Ribble Valley Borough Council
Council Offices
Church Walk,
Clitheroe
Lancashire
BB7 2RA

Phone: 0300 123 6780
Email: developeras@lancashire.gov.uk
Your ref: 3/2025/0758
Our ref: 3/2025/0758/HDC/KW
Date: 02 December 2025

Location: Land off Whalley Road Hurst Green (adjacent to Reed Deep BB7 9QJ)
Proposal: Proposed change of use of agricultural land to four no.1 bedroom holiday lodges, relocation of the site access, improvements to the public footpath and associated landscaping.
Grid Ref: 3689024 438046

Lancashire County Council acting as the Local Highway Authority does not raise an objection regarding the proposed development and are of the opinion that the proposed development will not have a significant impact on highway safety, capacity or amenity in the immediate vicinity of the site subject to the following conditions being stated on any approval.

Figure 3.3 : Swept Path Analysis – 11.2m Refuse Collection Vehicle

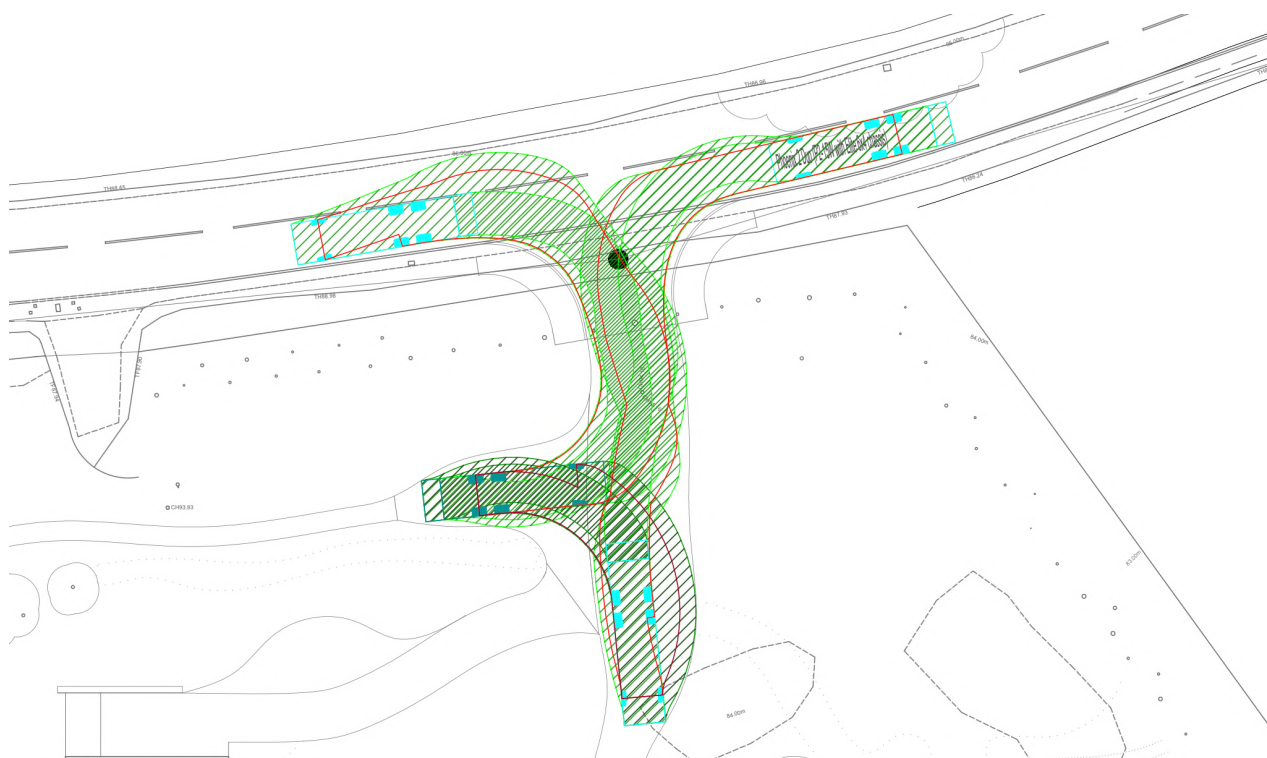
A turning head has been provided within the site and is supported by vehicle tracking information, for an 11.2m vehicle, as shown on drawing J32-8018-PS-002. This is acceptable, and shows refuse, emergency and delivery vehicles can enter and leave the site onto Whalley Road in forward gear.

1. The development hereby permitted shall not be occupied or brought into use until the car parking and turning areas shown on the approved plan(s) have been provided in full and are available for use. The car parking and turning areas shall thereafter be kept available for the parking and manoeuvring of vehicles at all times.
Reason: To ensure the provision of adequate car parking on site and in the interests of highway safety.
2. Secure cycle storage suitable for 8 bicycles shall be provided within the development.
Reason: To promote sustainable transport as a travel option, encourage healthy communities and reduce carbon emissions.

client: chris hickey
project: whalley road, hurst green
project number: J328018
scale: 1:1000@A3
drawing title:
preliminary site location and visibility splays
drawing number:
J32-8018-PS-001

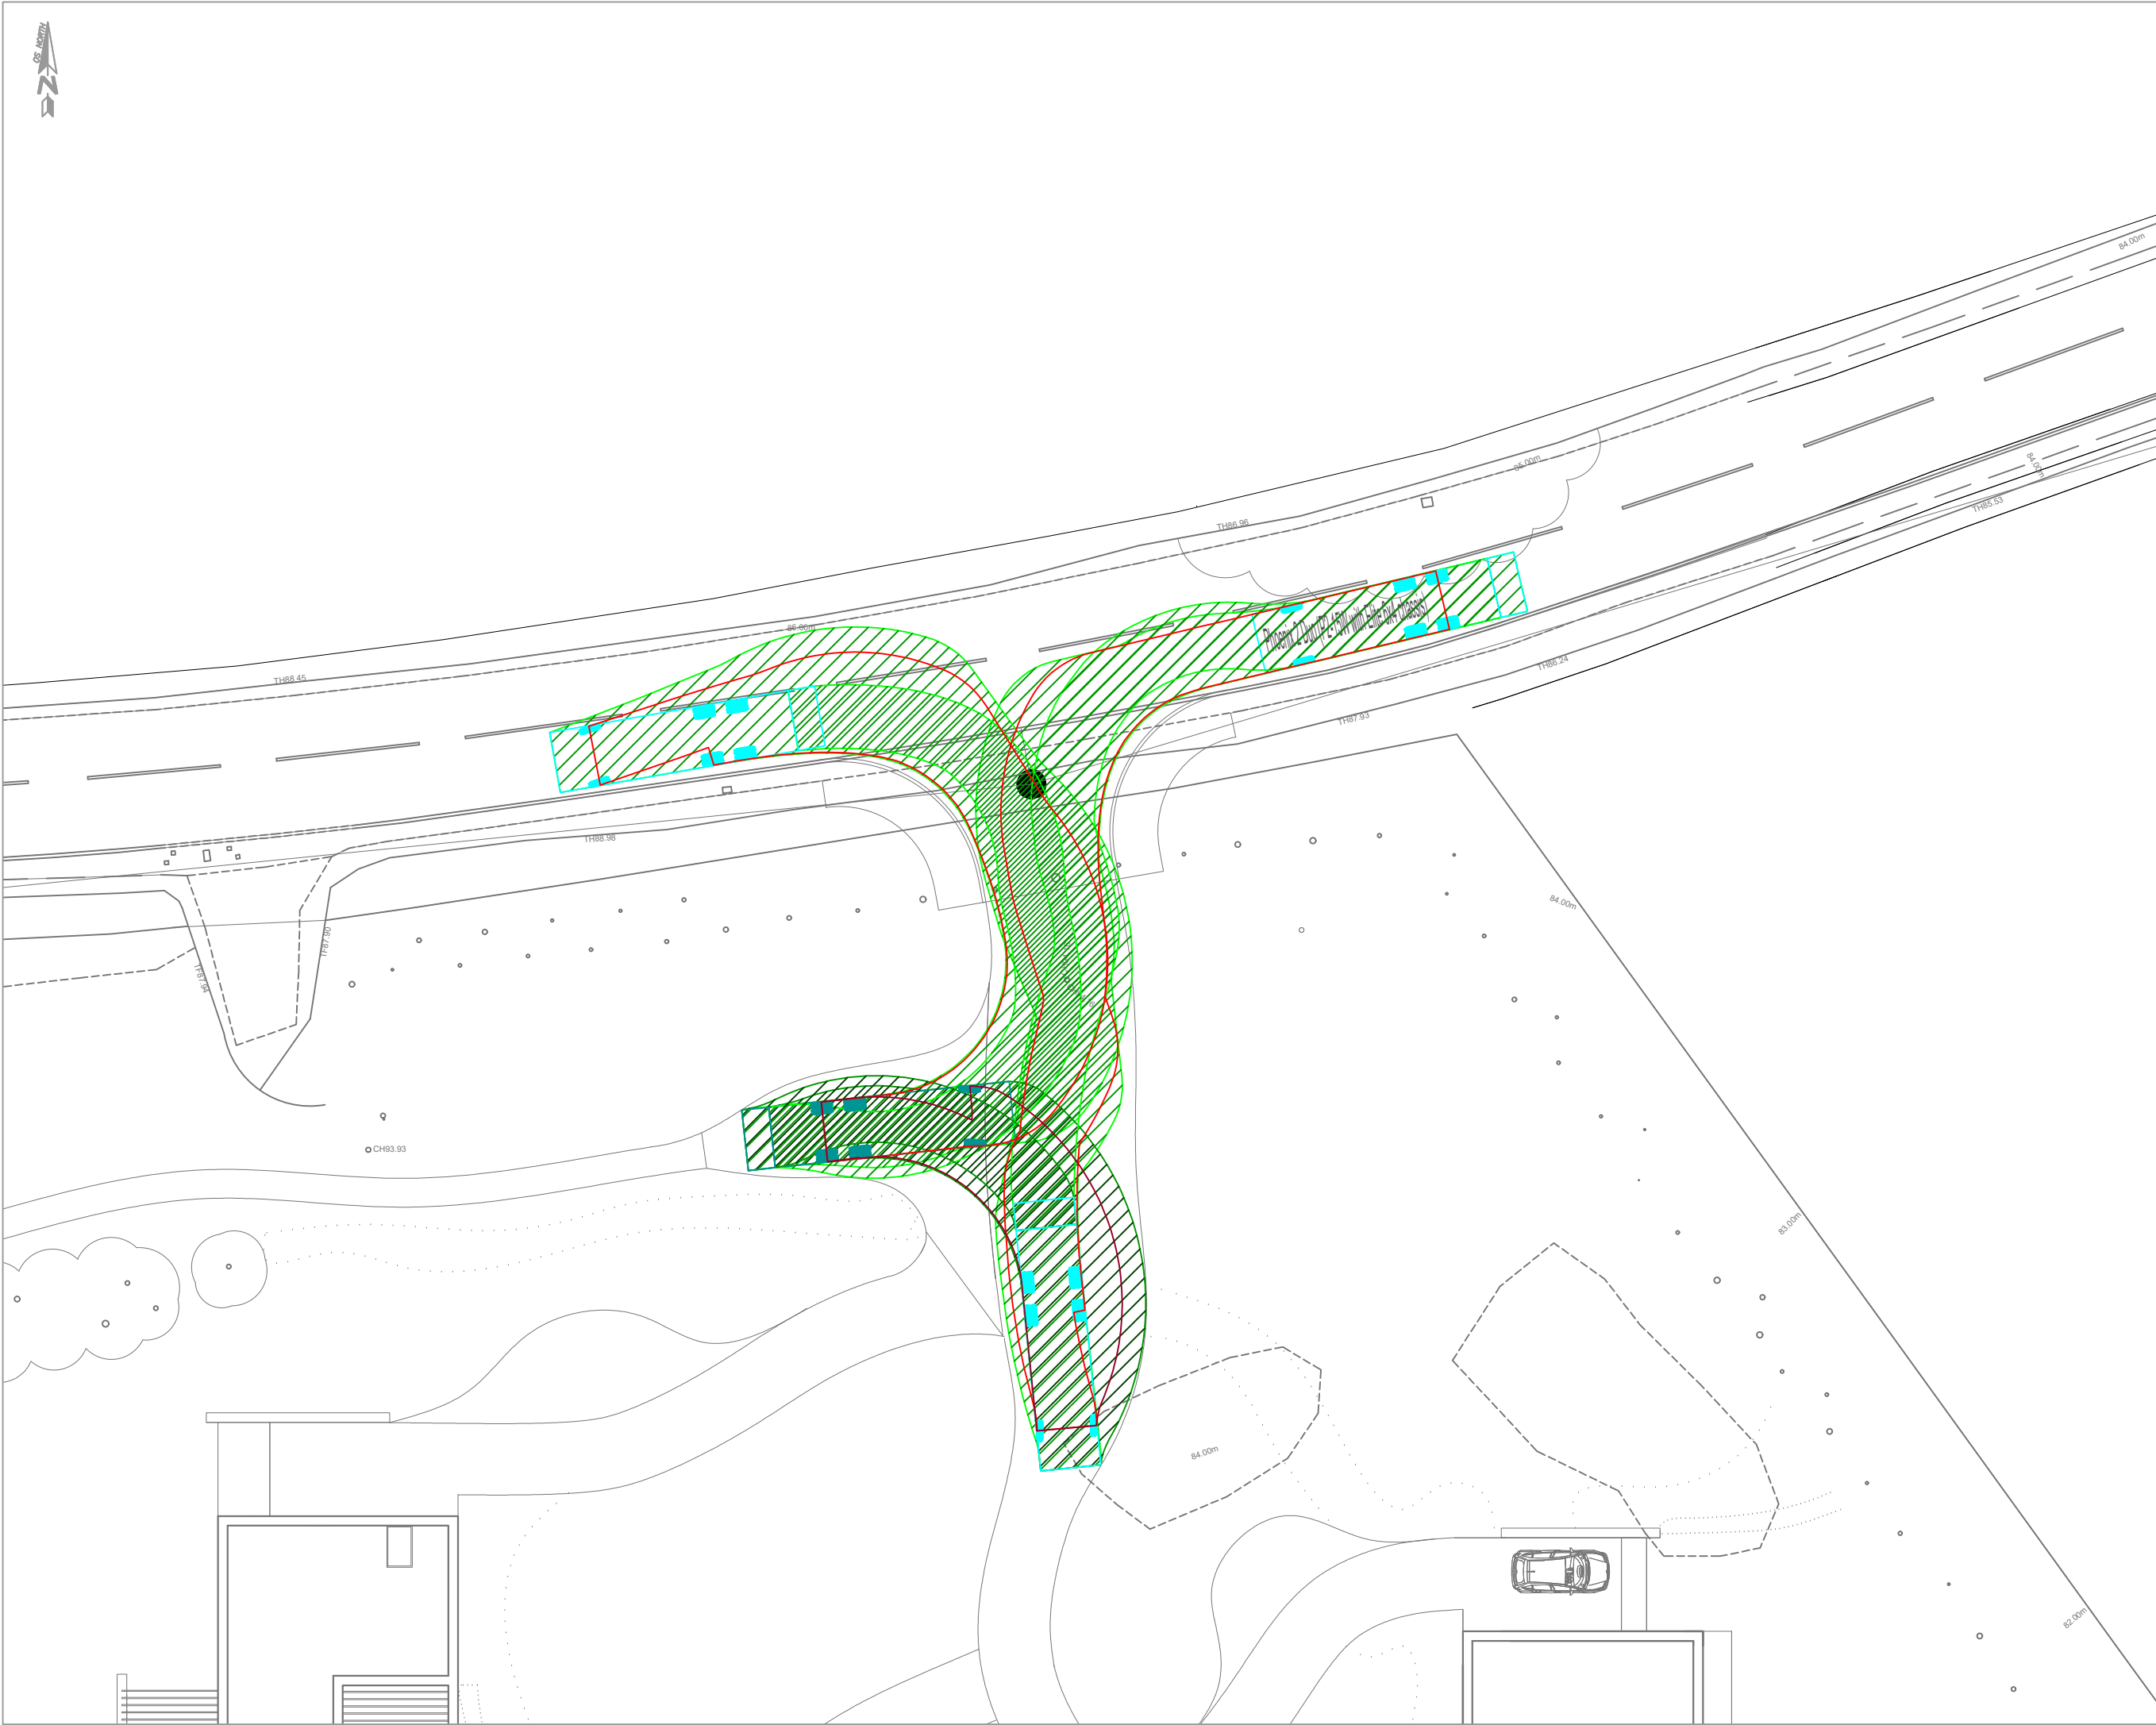
A new access point, which sits to the East of the site, is proposed. The new site access is proposed at 5.5m wide with 2m wide footways which is acceptable for the nature of the site. The first 5m must be hard paved and constructed to LHA's specifications. The applicant undertook an automatic traffic count on Whalley Road, in proximity of the site between 8th – 14th March 2024, which showed that the 85th percentile of traffic speed was 41.5mph westbound and 43.8mph eastbound. This requires visibility splays of 2.4m x 119.8m to the west and 109.7m to the east.

The LHA has reviewed Drawing J32-8018-PS-001, Rev D which provides an acceptable visibility in line with the requirements above. Where the visibility splay crosses the boundary hedge, the hedge should be reduced in height to no more than 0.9m above the carriageway level. The boundary hedge which fronts Whalley Road would also benefit from being cut back due to its encroachment on the adopted footway to ensure the splays are clear and to support pedestrian movements.

8. No building use hereby permitted shall be commence until visibility splays 2.4 metres back from the centre line of the access and extending 120m to the west and 110m to the east has been provided at the access, as shown on the approved plans. Nothing shall be erected, retained, planted and / or allowed to grow at or above a height of 0.9 metres above the nearside carriageway level which would obstruct the visibility splay. The visibility splays shall be maintained free of obstruction at all times thereafter for the lifetime of the development.
